From: Amanda Scholes on behalf of Planning.Responses
Sent: 16 October 2019 08:31
To: Planning Scanning
Subject: FW: White Cottage, Walberton (WA/22/19/PL)

From: Laura Gibbons [REDACTED]
Sent: 15 October 2019 15:53
To: Julia Davies [REDACTED] Andrew Wood [REDACTED]
Subject: RE: White Cottage, Walberton (WA/22/19/PL)

From: Julia Davies [REDACTED] <>
Sent: 14 October 2019 13:11
To: Andrew Wood [REDACTED]
Cc: Laura Gibbons [REDACTED]
Subject: White Cottage, Walberton (WA/22/19/PL)

Pit to be 2 x 1.5 x 0.8m deep

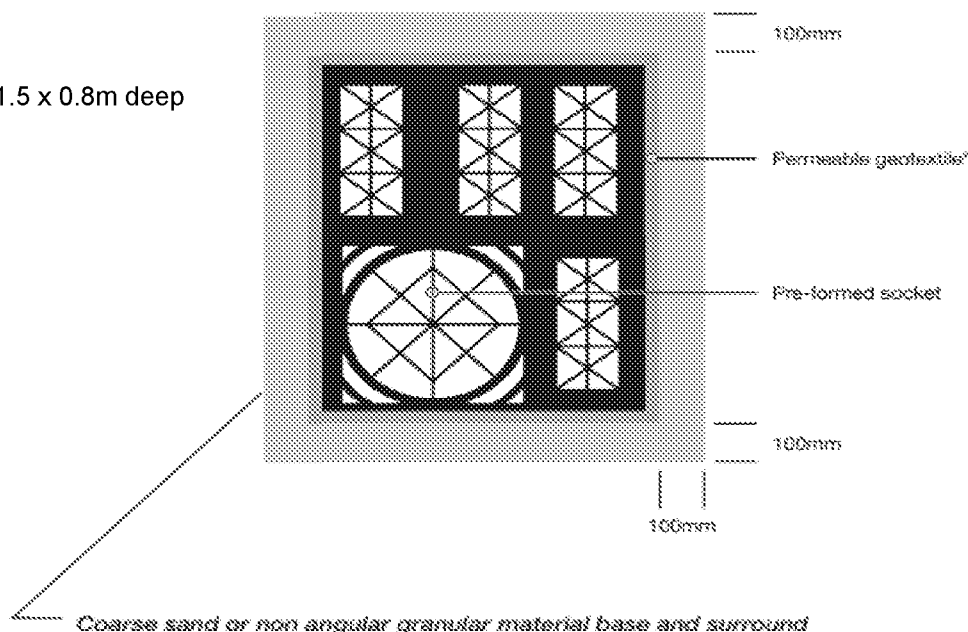
The infiltration test was completed at shallower depths than the proposed infiltrating structures, as a result we require a Factor of Safety of 3 to be used in design.
